# **Moore College Newtown Concept Plan**

## **Strategy for the Provision of Access for People with Disabilities**

**October 2009**

**Prepared by:  
Access Associates Sydney**

Figure CP 2001: Basement level 1 plan

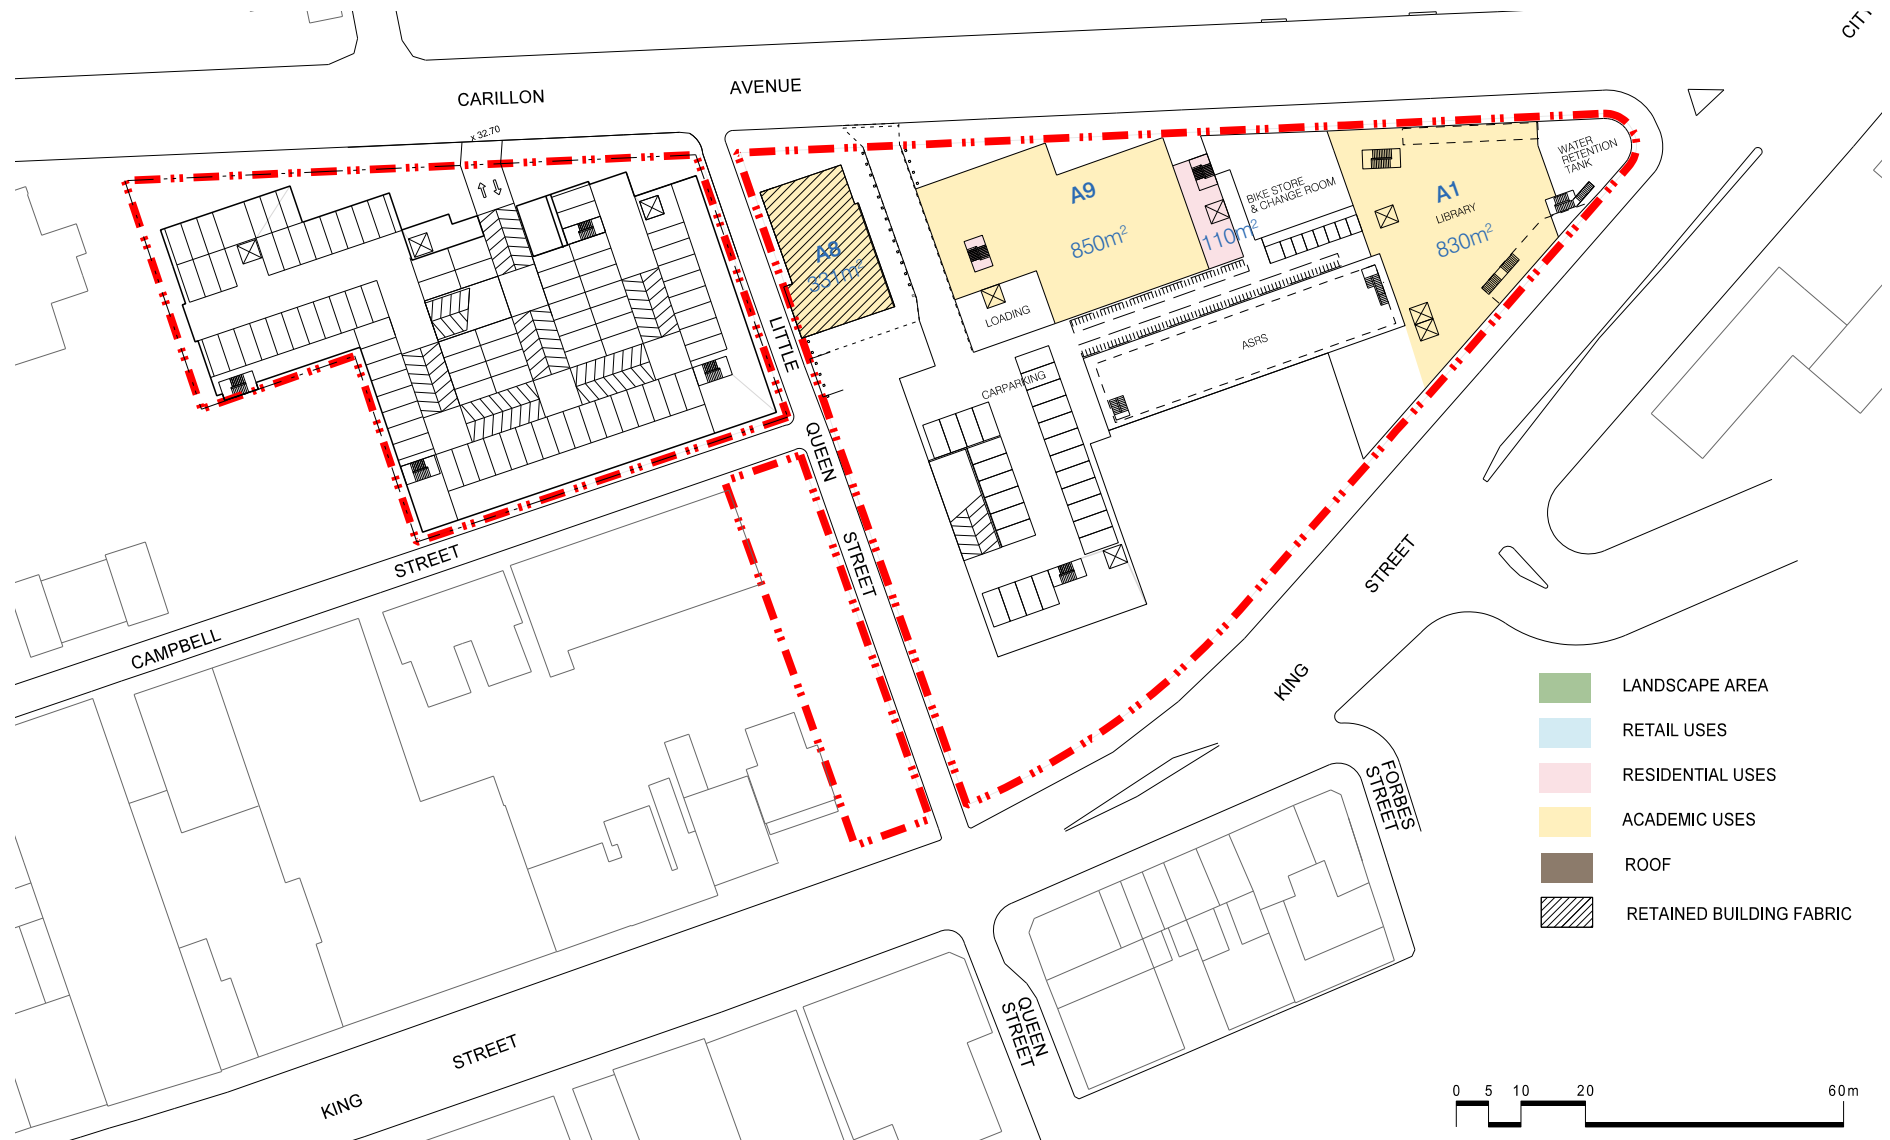
- Accessible parking spaces are required in the basement proposed for the new library on site A, where future parking for the facility is indicated over 2 levels and linked via an accessible path of travel to the ground floor lobby.
